Project: **EPPING PARK, 61 MOBBS LANE EPPING**

Report: **BCA ASSESSMENT REPORT ON
BUILDINGS 3, 4, 5 AND 7**

Date: 27th April 2009

Building 5 Basement Carpark

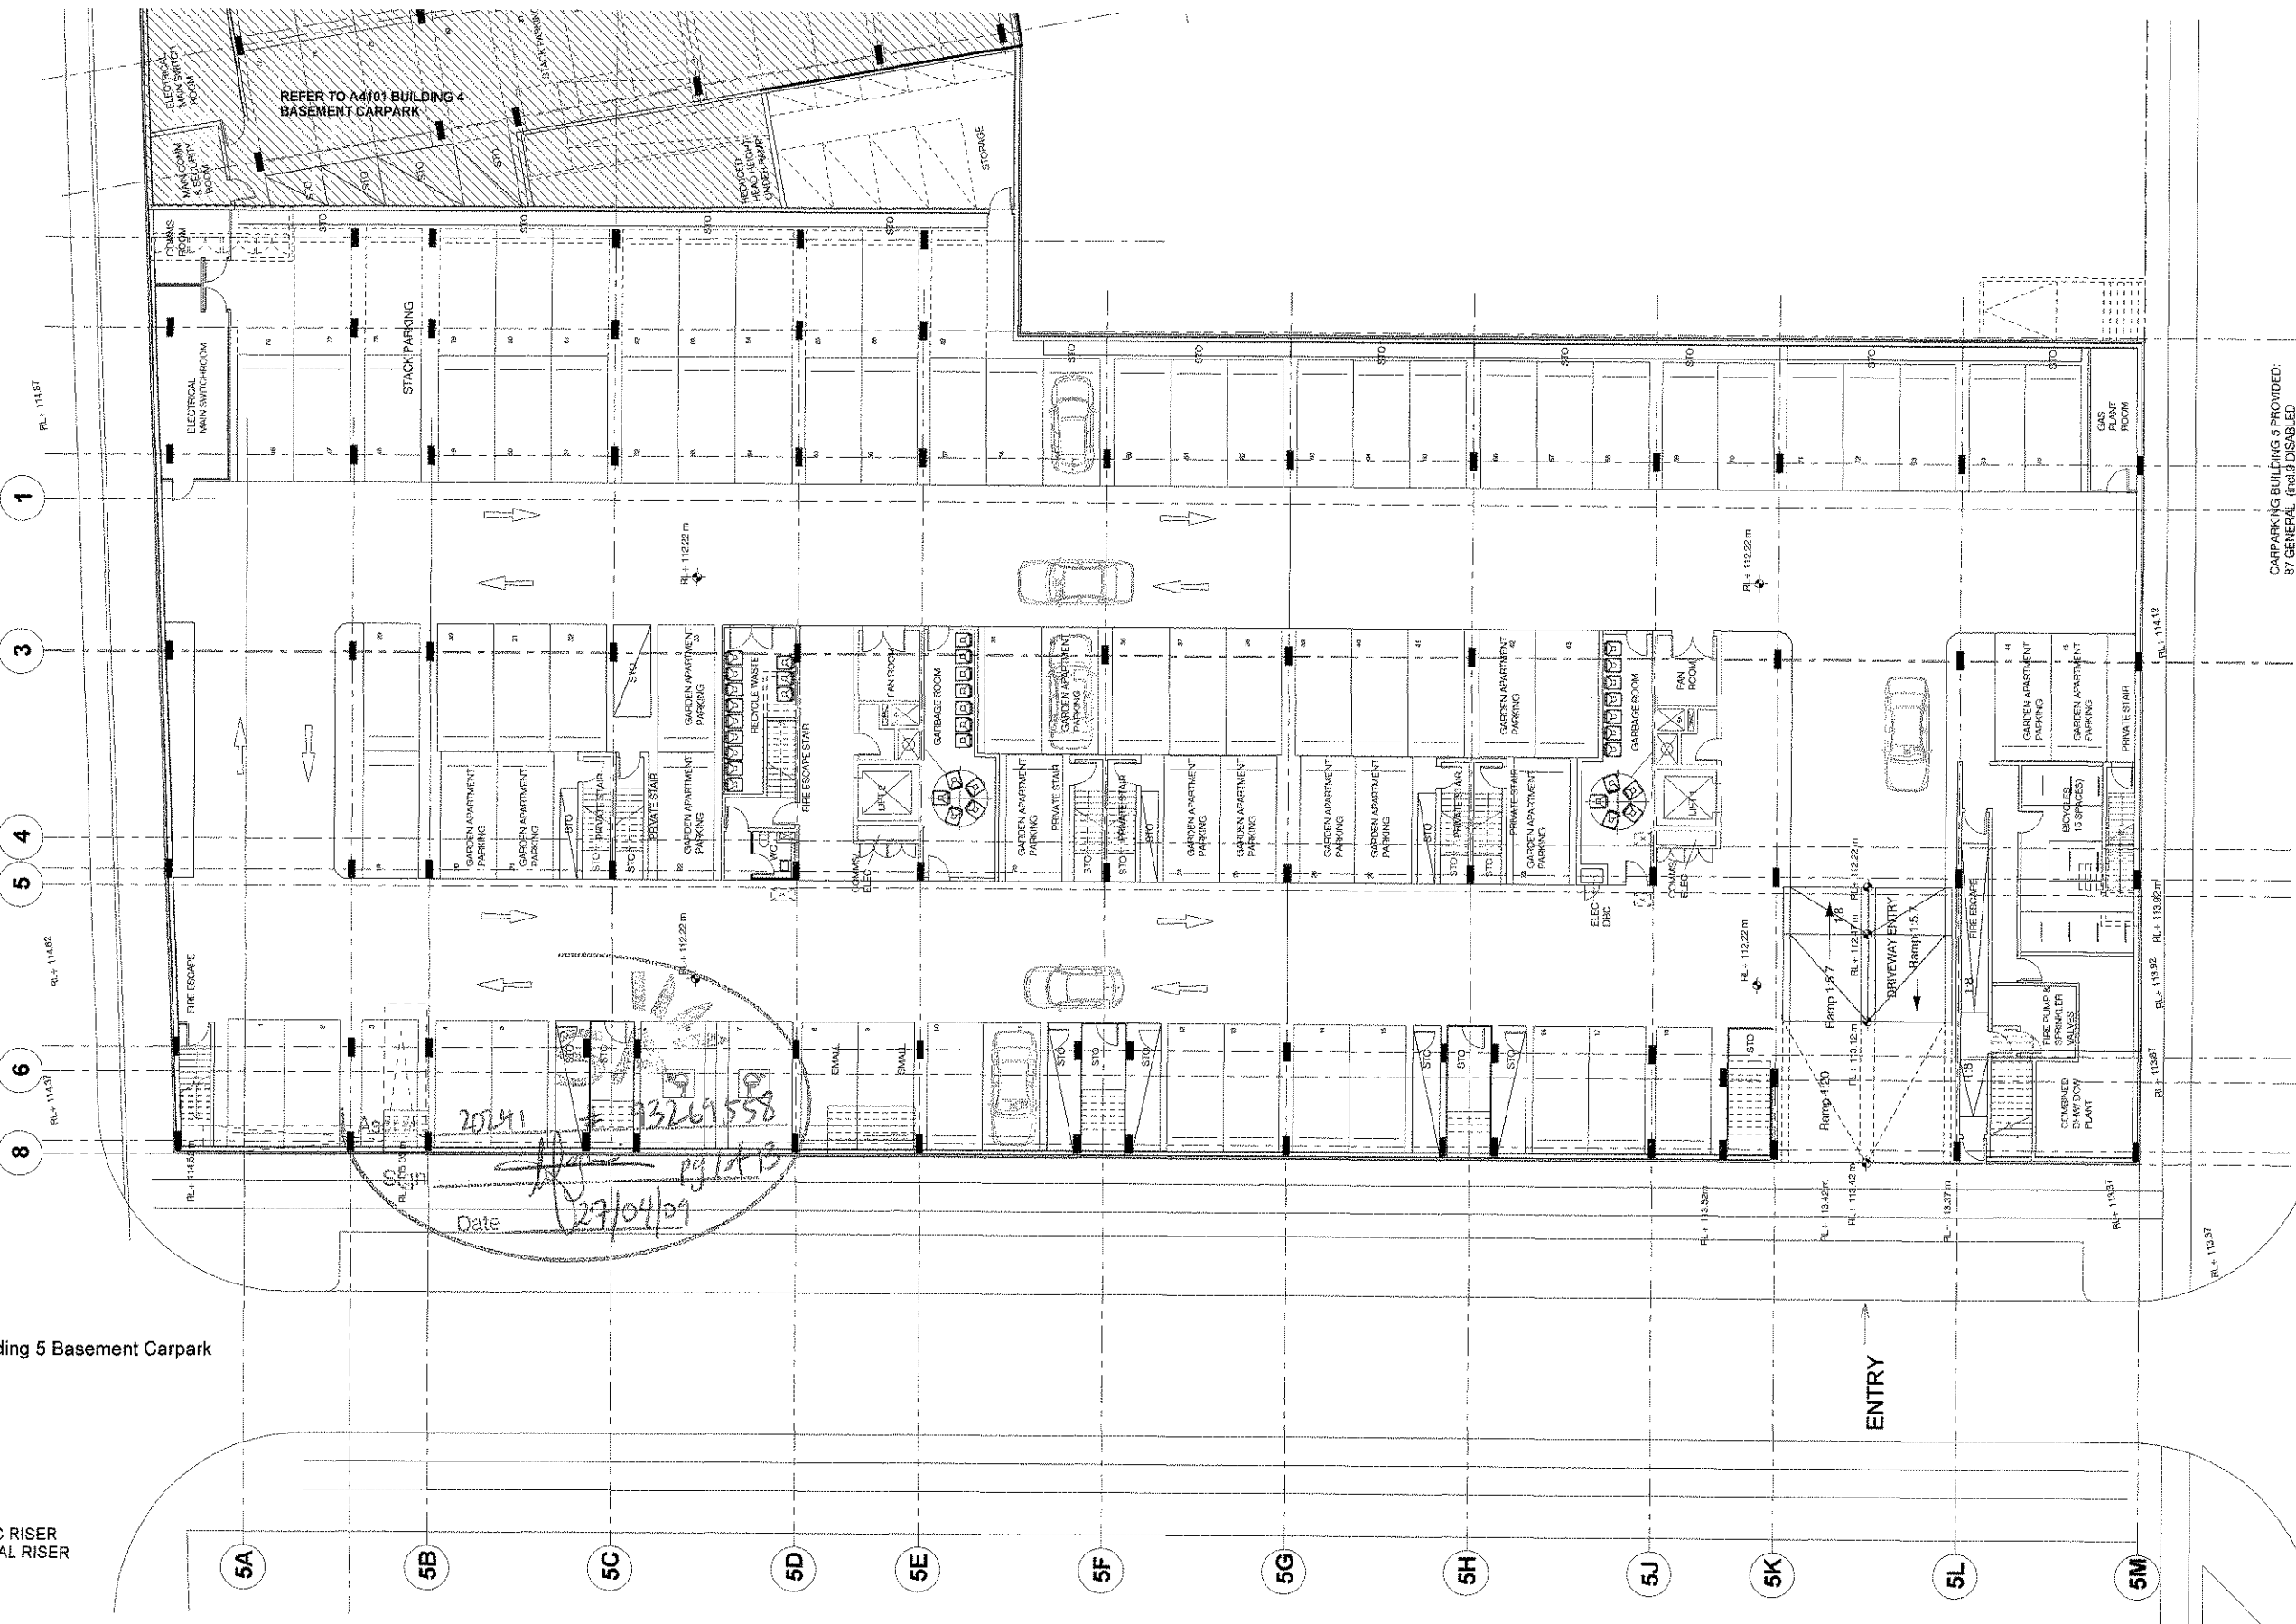
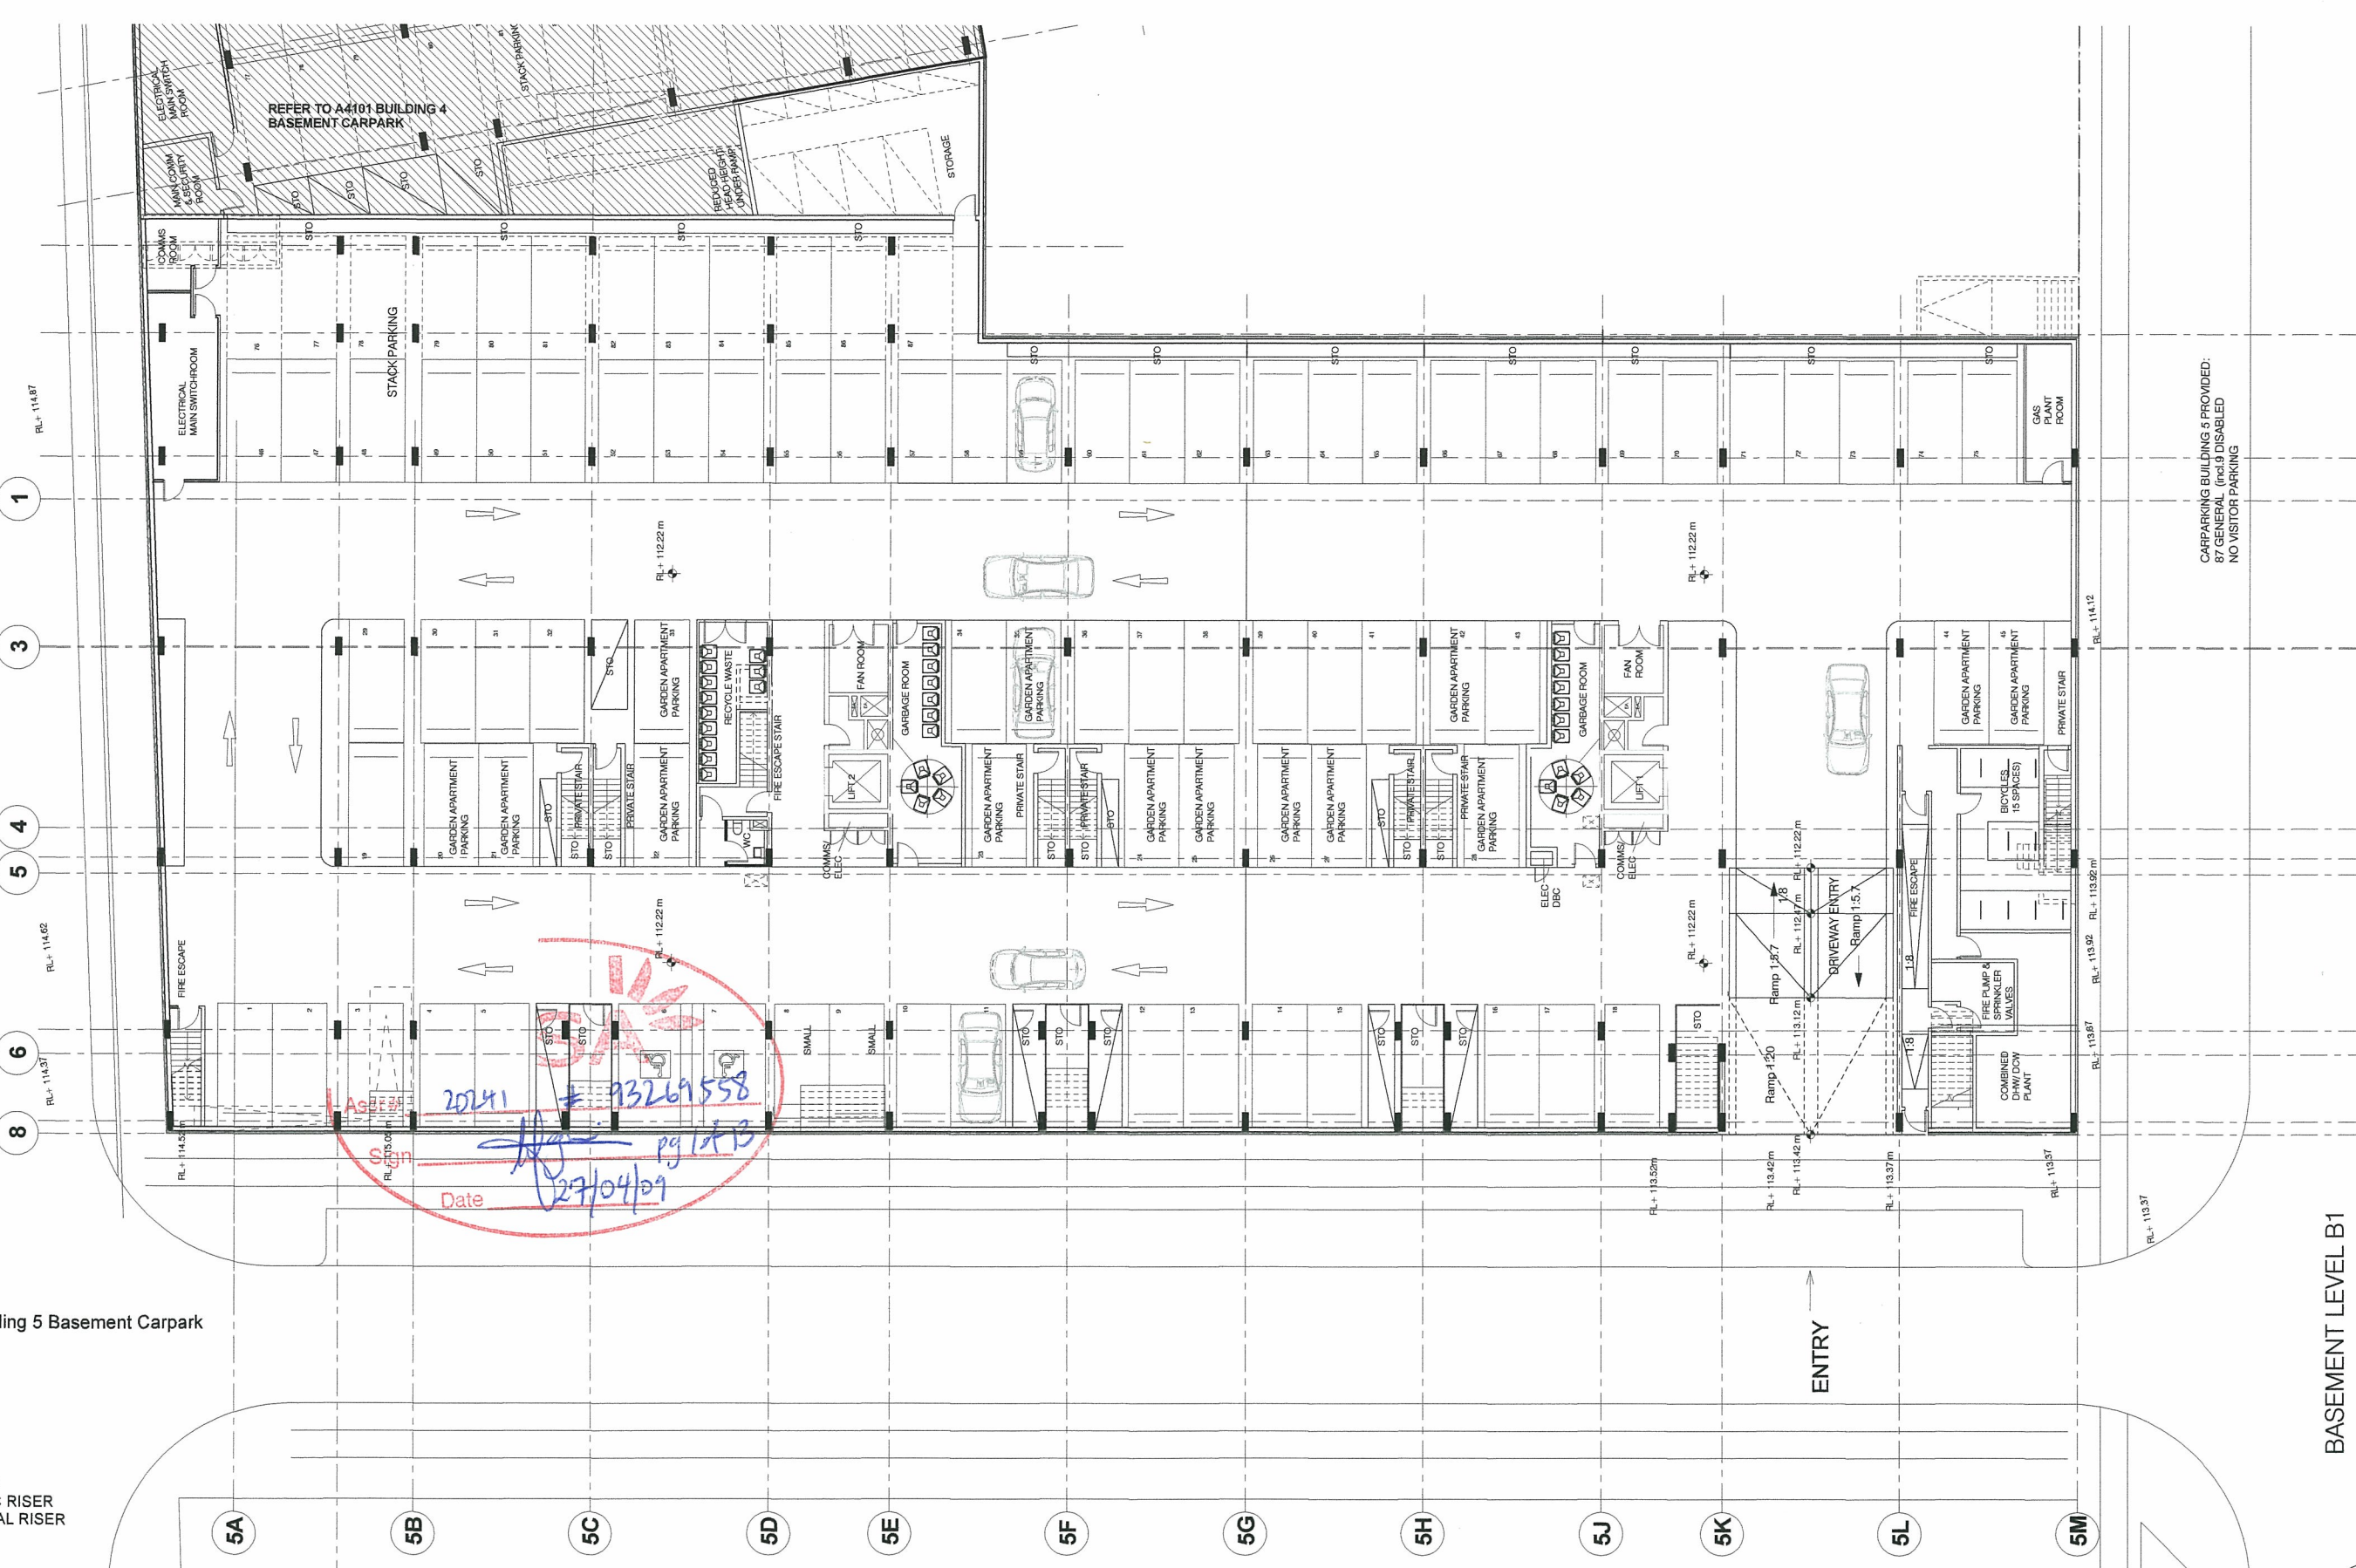
Notes: There are FRL concessions applicable for fully sprinkler protected car park portions under Clause 3.9 of Specification C1.1 of the BCA reducing the car park FRL's down from 120/120/120 to 60/60/60. As a portion of the roof deck of the basement level car park to Buildings 4 / 5 is required to be used as true "open space" for the purposes of egress this portion of the car park and supporting structure must have an FRL of 120/120/120 as required by D2.12.
